Sent: 11 November 2010 16:22
To: Planning
Cc: Heywood Karen, Bewick Stewart, Martin Edward, Anita Ward
Subject: Application N6/2010/2055/MA Shredded Wheat Factory, Welwyn GC

Please find below Network Rail's response to the application for development of the former Shredded Wheat factory at Welwyn Garden City (N6/2010/2055/MA).

02. BRIDGE LEVEL PLAN : PROPOSED

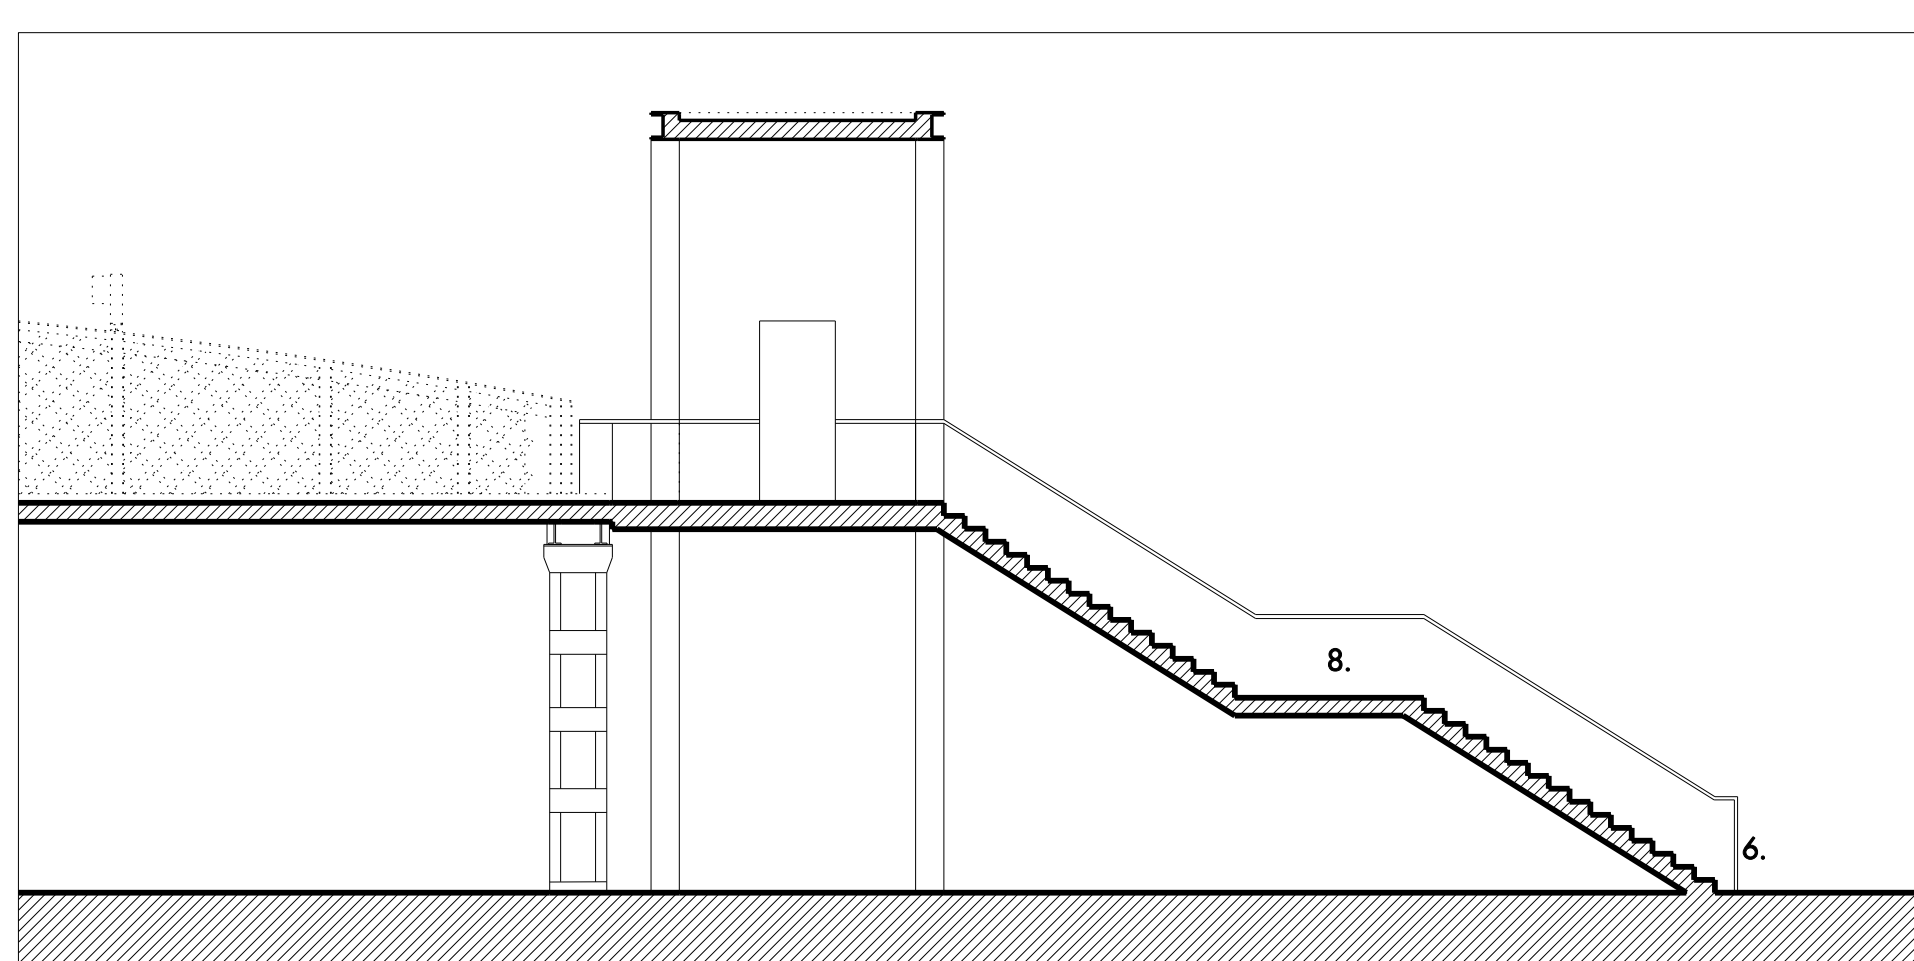
The proposal as tabled provides for the removal of the redundant spans at the east end of the structure and the provision of a new staircase and lift to gain access to the bridge, station and Howard Centre beyond. However there is no consideration of the increased use of the footbridge as a result of the overall development; there are no figures (as far as can be ascertained) on what the increased footfall over the bridge would be overall. Mention is made of perhaps an additional 200 or so rail trips associated with the development but there is no estimate of how many people would use the bridge to gain access to the town centre, or how many would go in the opposite direction on foot to the various uses proposed (particularly the supermarket and leisure centre). Our immediate concern is whether the existing bridge structure could cope with the increased footfall resulting from the development. This work should emerge as part of the feasibility study currently being carried out. We hope to have some initial feedback on this w/c 22nd November, so we will have to reserve judgement on this particular aspect until that week at the very least.

Clearly we are supportive of the proposal to shorten the existing bridge spans but the option tabled represents the least form of improvement in terms of attractiveness and does not reflect the aspirations of the Authority as expressed in the development brief. We would also be concerned about potential pinch points within the retained structure if there is a significant increase in footfall predicted. Additional issues such as the maintenance of the new structures will also have to be taken into account. As such we would expect the results of the feasibility study discussed above to influence the determination of the application with respect to these aspects of the proposal.
